DRAINAGE AND TRANSPORTATION INFORMATION SHEET

December 23, 2022

**RE: MONTGOMERY / WYOMING APARTMENTS
4615 WYOMING BLVD. NE
TRAFFIC CIRCULATION LAYOUT RESPONSE TO COMMENT**

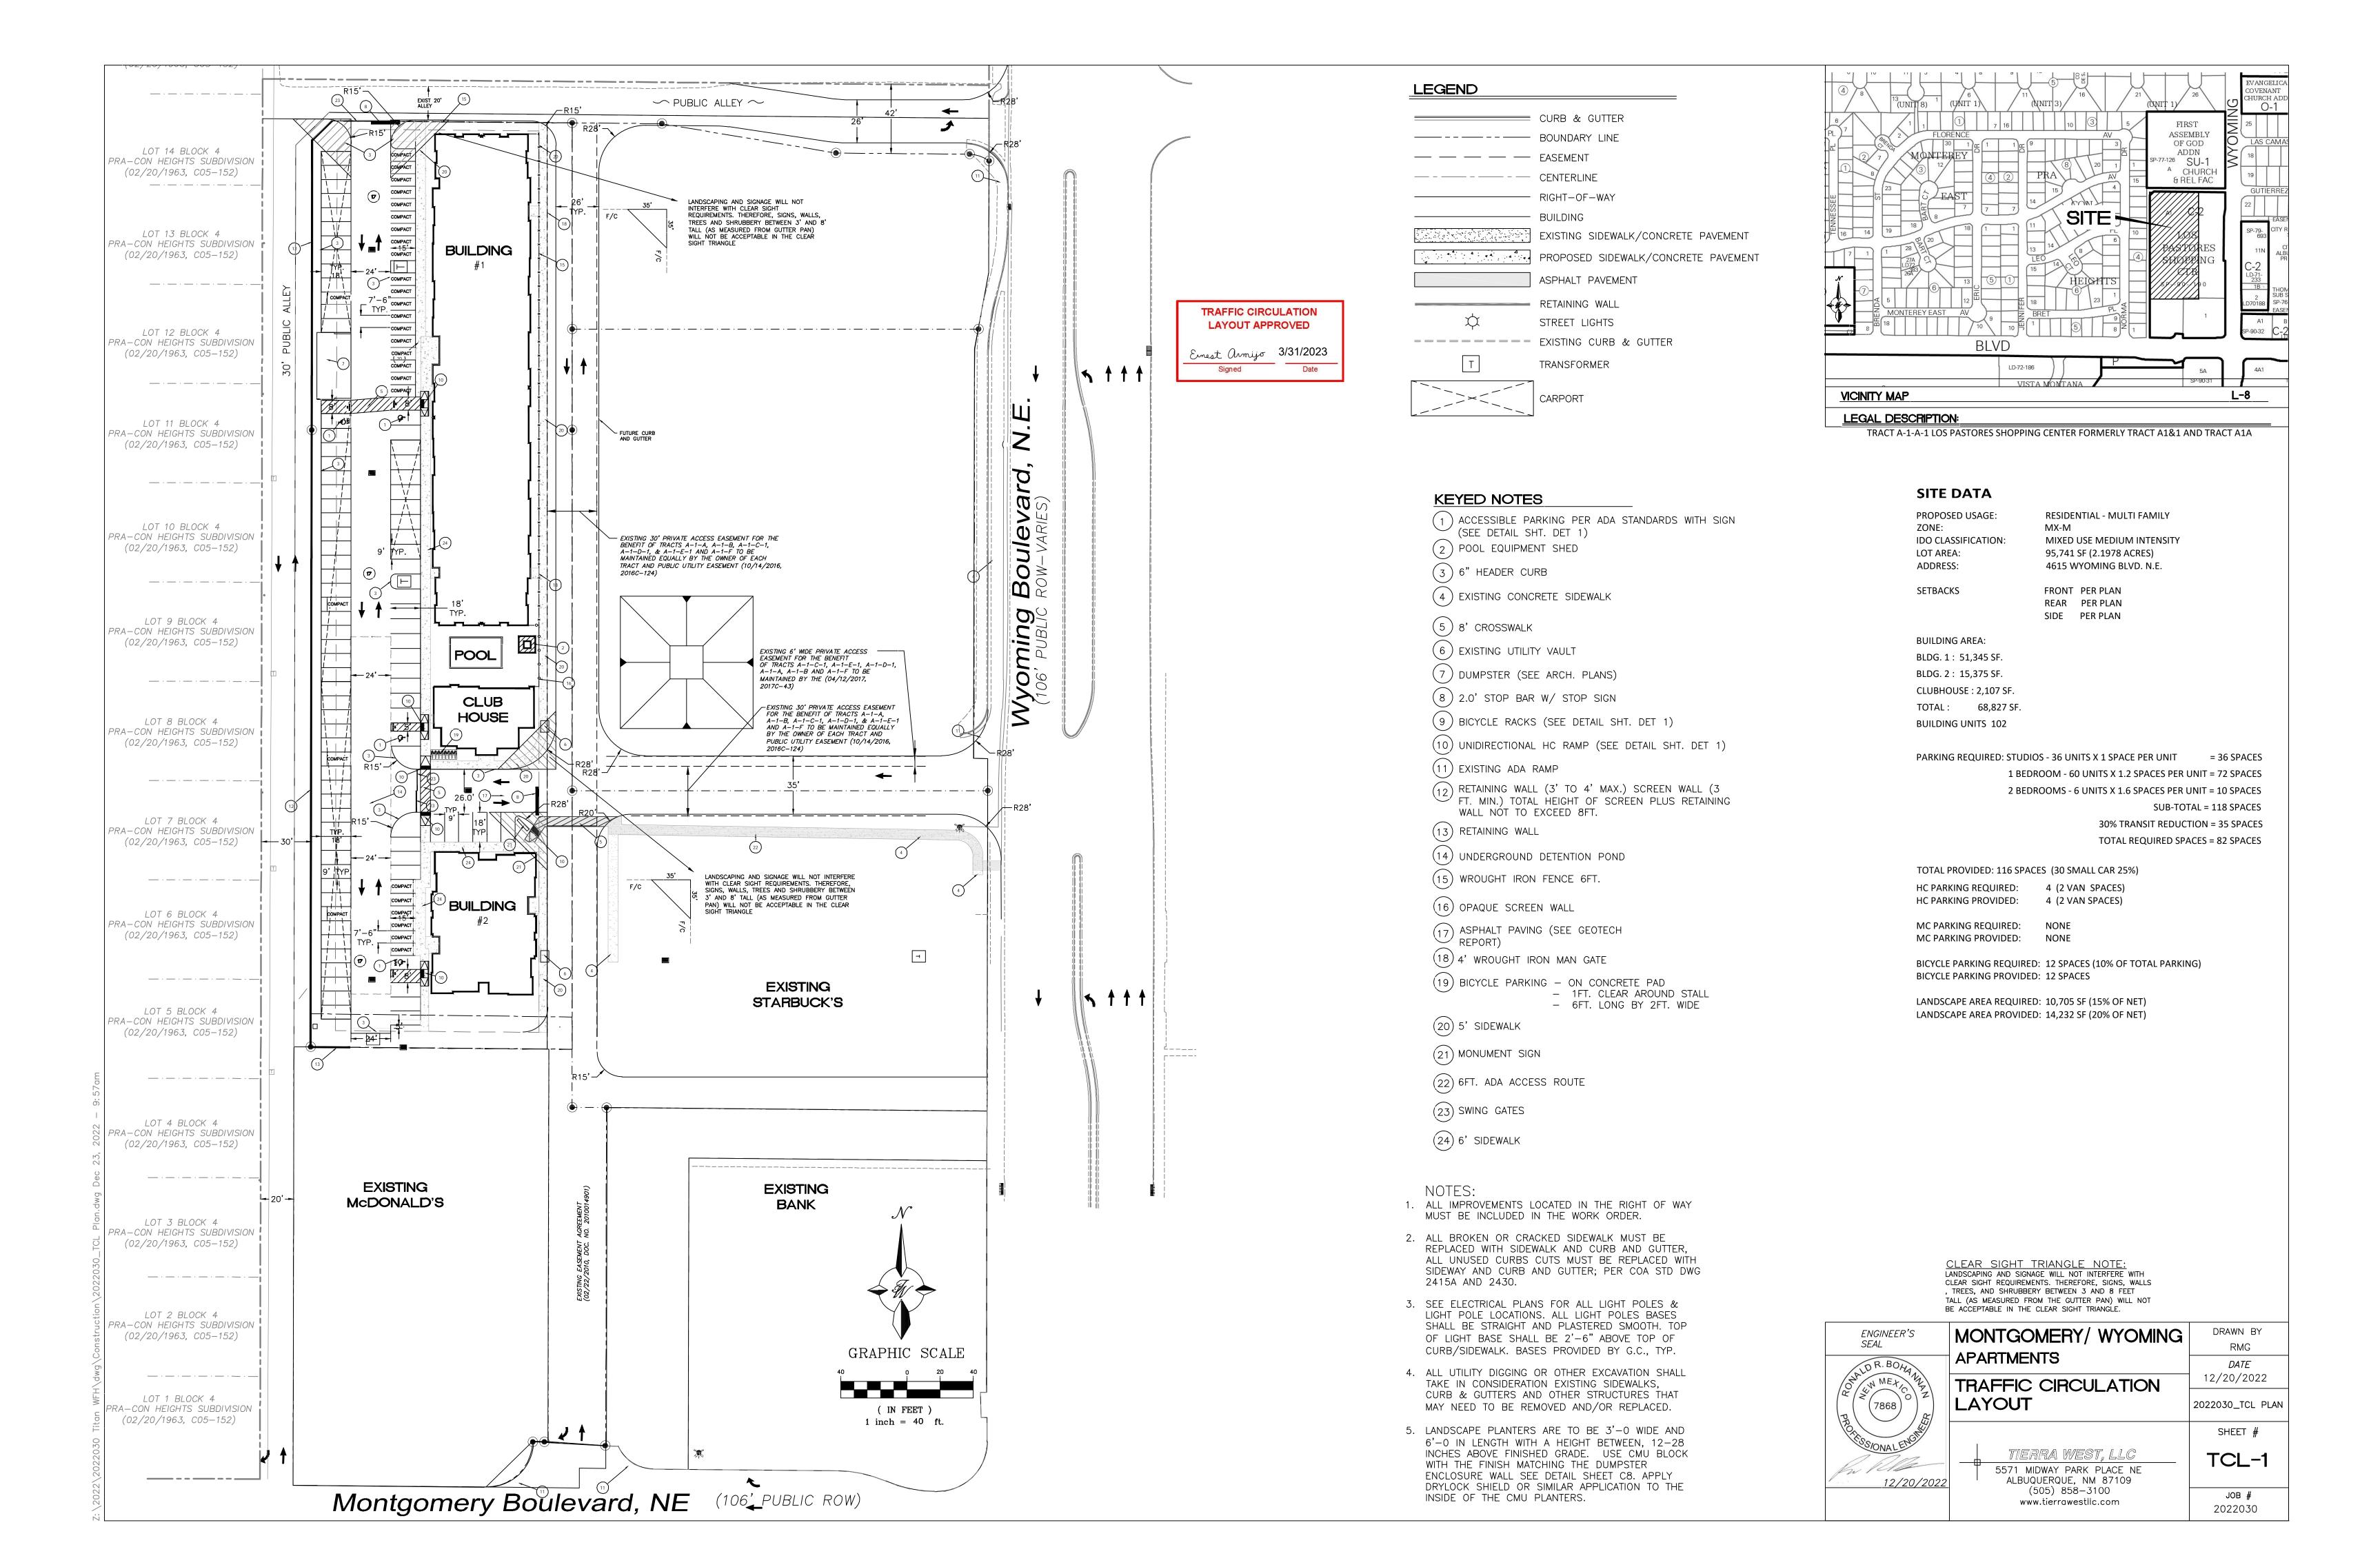
1. Identify all existing access easements and rights of way width dimensions.
Response: Added easements and right of way information to the site plan.
2. Please provide shared access agreement, and approved plat.
Response: See attached copy of approved Los Pastores plat and proposed sketch plat. The proposed development will require elimination of a lot line to consolidate two lots into one. Offsite access easements will remain in place as shown on sketch plat.
3. Details sheet is missing.
Response: The detail sheet was added along with an architectural sheet for dumpster details. Consensus is working with Solid Waste on approval of the layout.
4. Please list the width and length of all proposed parking spaces. Some dimensions are not shown.
Response: Additional dimensions on parking added.
5. The minimum parking stall dimensions are:

6. The ADA accessible spaces must include an access aisle. Van accessible aisles should be 8ft wide; all others should be 5ft wide.
Response: Aisle widths on van spaces were corrected to 8'.

Response: A 5' keyway included in dead-end parking aisle with dimension on plan.
16. Per the IDO, a 6ft. wide ADA accessible pedestrian pathway is required from the public sidewalk to the building entrances. Please clearly show this pathway and provide details.

Response: Sidewalks increased to 6' where required to meet ADA requirements.
17. Per DPM, a 6 ft. wide ADA accessible pedestrian pathway is required from the ADA parking stall access aisles to the building entrances. Please clearly show this pathway and provide details.

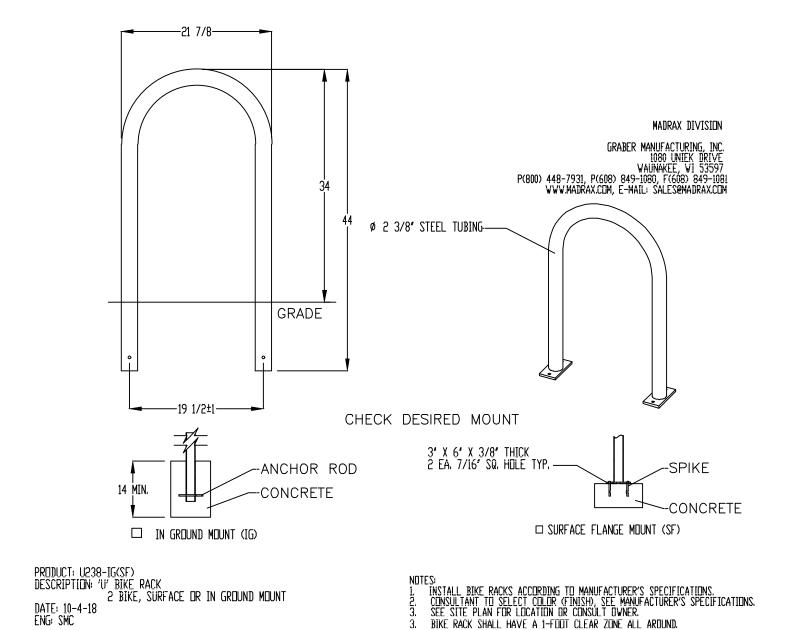
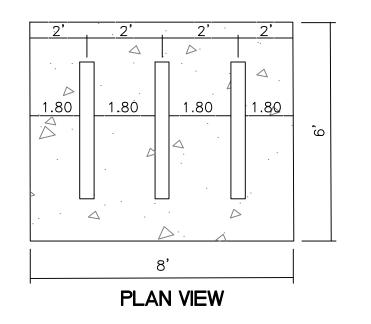
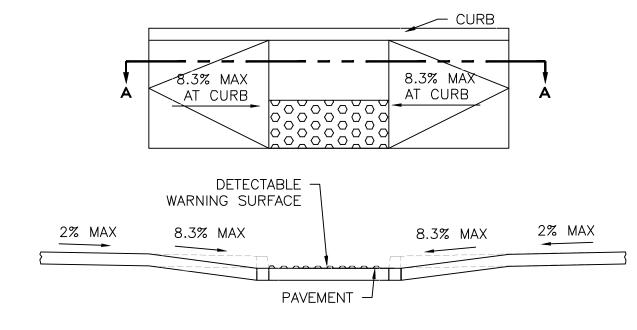
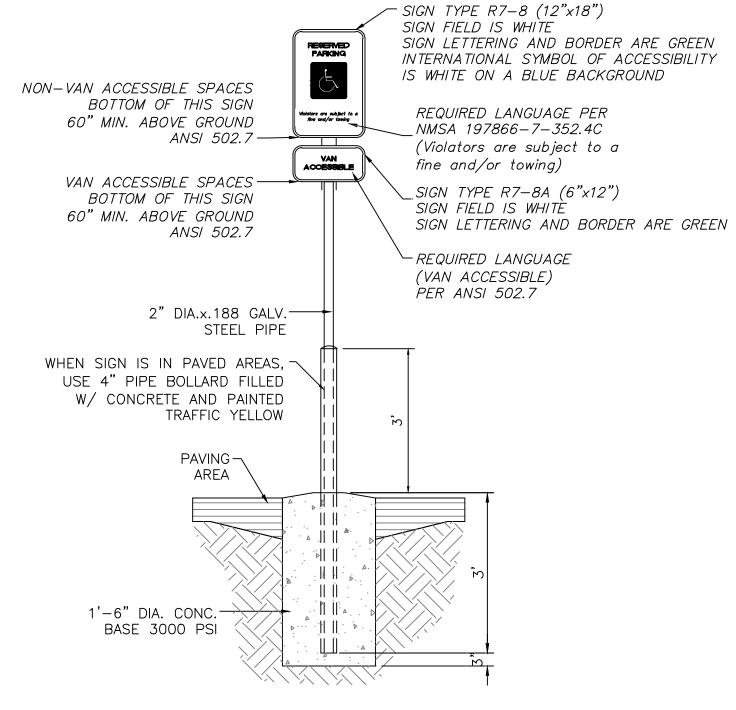
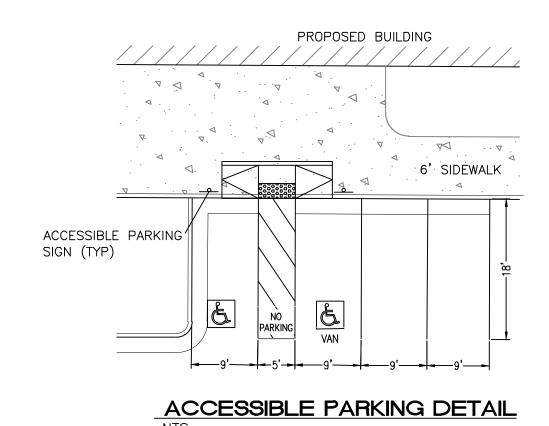
7. The ADA accessible parking sign must have the required language per 66-7-352.4C NCSA 1978 “**Violators Are Subject to a Fine and/or Towing.**” Please call out detail and locations of signs.

Response: Required language noted on ADA parking sign detail on detail sheet.
8. ADA curb ramps must be updated to current standards and have truncated domes installed.

Response: Ramps shown on detail sheet with required truncated domes.
9. Key note 10: Provide details for all the interior ADA ramps.
Response: Details provided on attached detail sheet.
